**Consultation Response from KC,  
Trees**

**2023/93031 Wappy Springs Inn, Lindley Moor Road, Lindley Moor, Huddersfield, HD3 3TD  
Erection of mixed industrial development (Use Classes E(g)(i, ii, iii), B2 and B8); including  
demolition of existing structures, new yard, parking, landscaping, drainage features and  
ancillary structures**

**Date Responded: 07/12/2023**

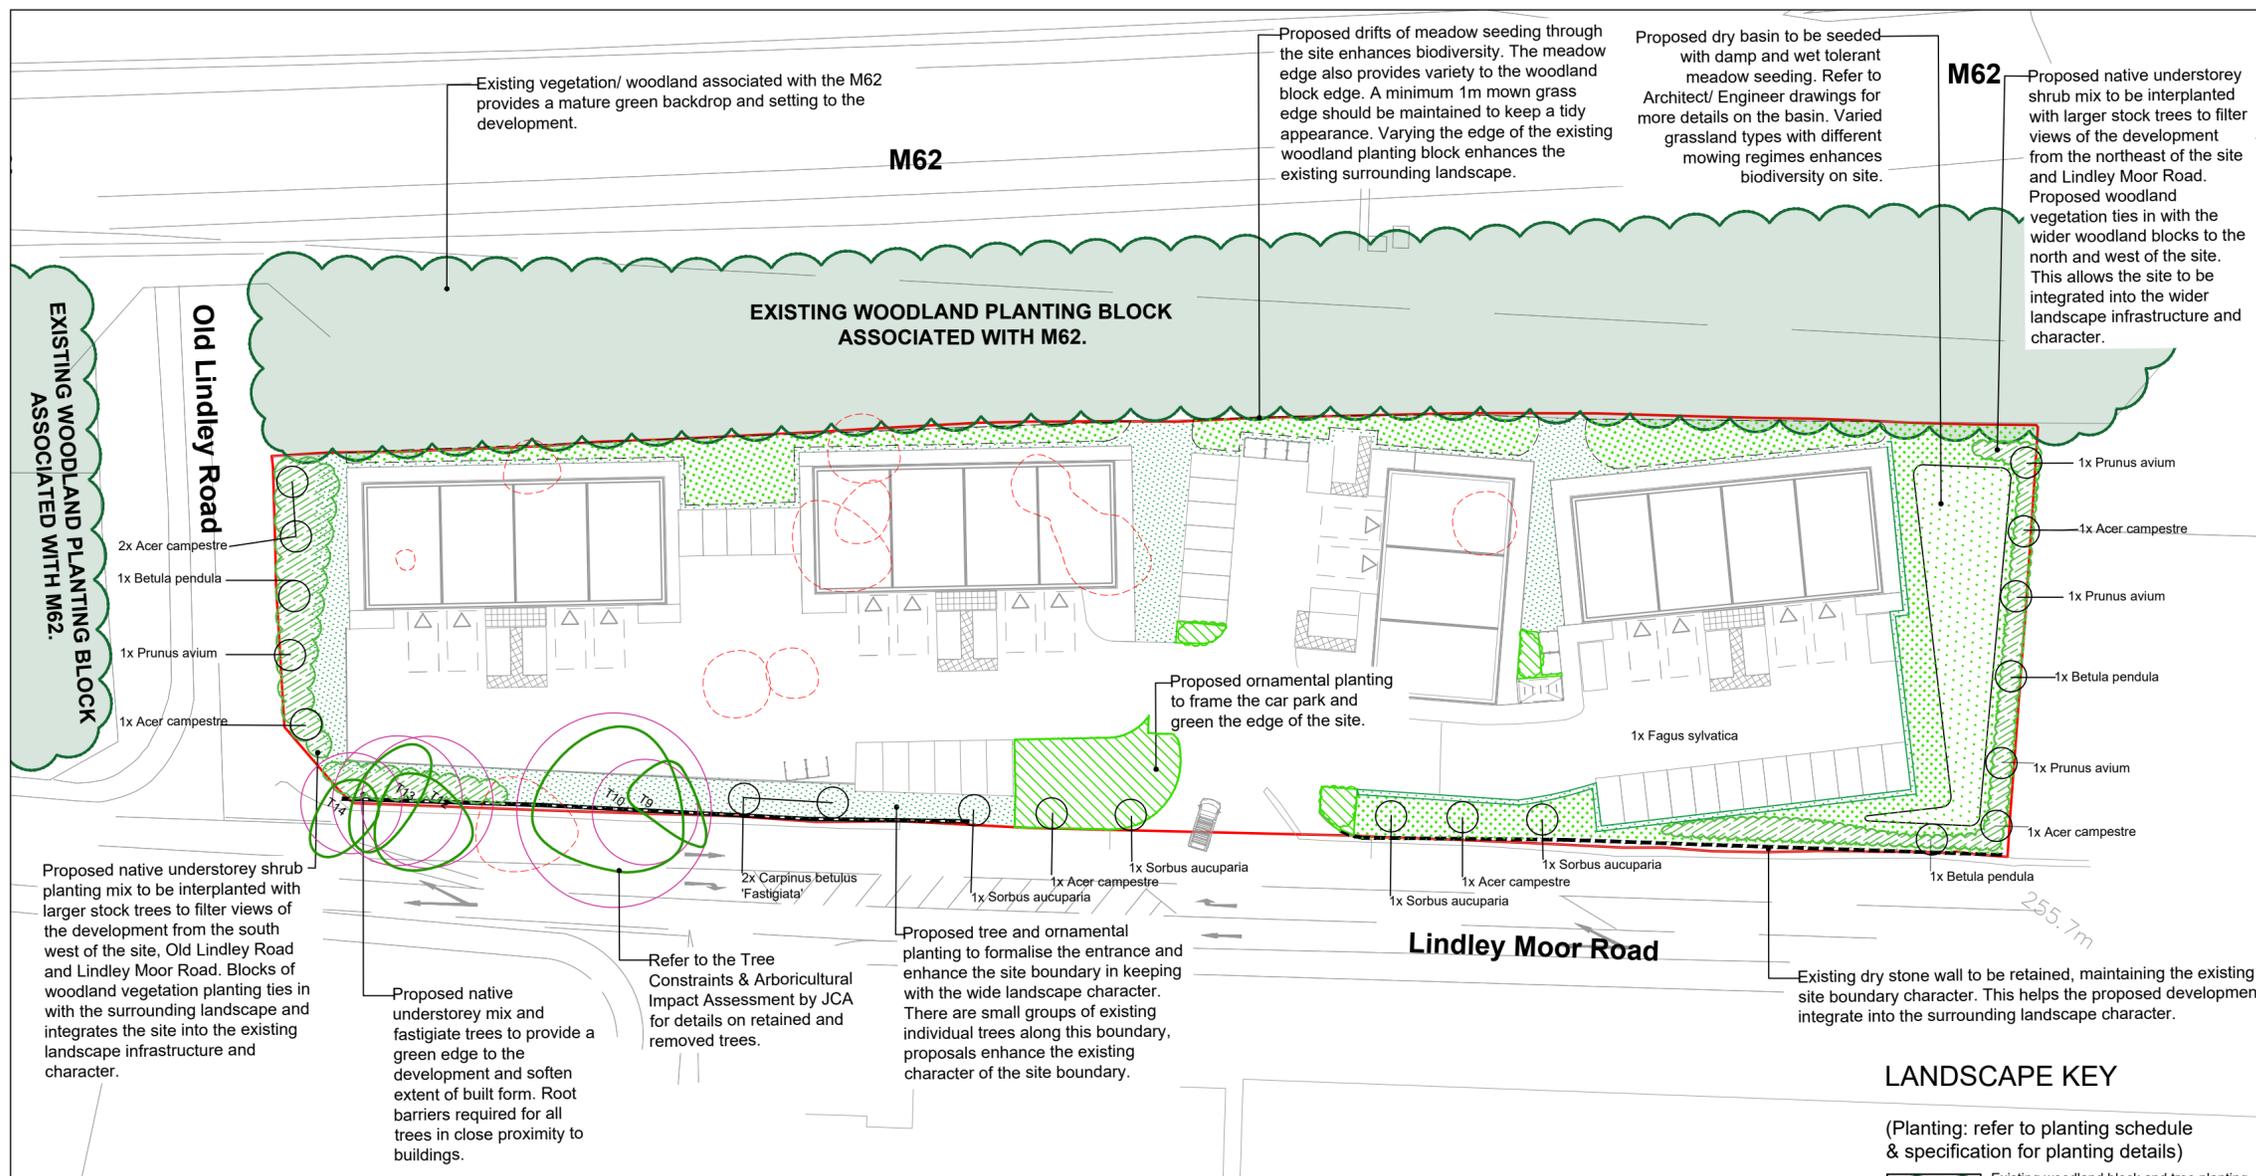
There appears to be a disconnect between the Arbouriculture Impact Assessment (AIA) and the other plans/information with Design and Access Statement (DAS) and the outline soft landscaping plan (Drawing No. PWP.538.001 Rev 4).

The DAS and the outline soft landscaping plan show trees T9, T10, T12, T13 and T14 as being retained while the AIA (Ref 16987-B/AJB) doesn't.

This conflict needs to be resolved.

Based on the tree survey schedule alone at the moment (pending a site visit), T10 would be in KC trees opinion merit retention and protection in the scheme.

From the others, its apparent from the survey there are defects present and are mostly unremarkable. So their removal maybe tolerable subject to the soft landscaping scheme replacing along that section of the boundary with appropriate species and nursery stock.

- Highlight areas designated for structural landscaping that need to be protected from construction operations in order to prevent the soil structure being damaged based on PWP.538.001 Rev 04 as amended.
- Evaluation of tree constraints the retention of T10 would result in and draft tree protection plan for T10 and G1 during construction.
- Discuss issues to be addressed by an arboricultural method statement to ensure the realistic retention of T10, and where necessary in conjunction with input from other specialists.
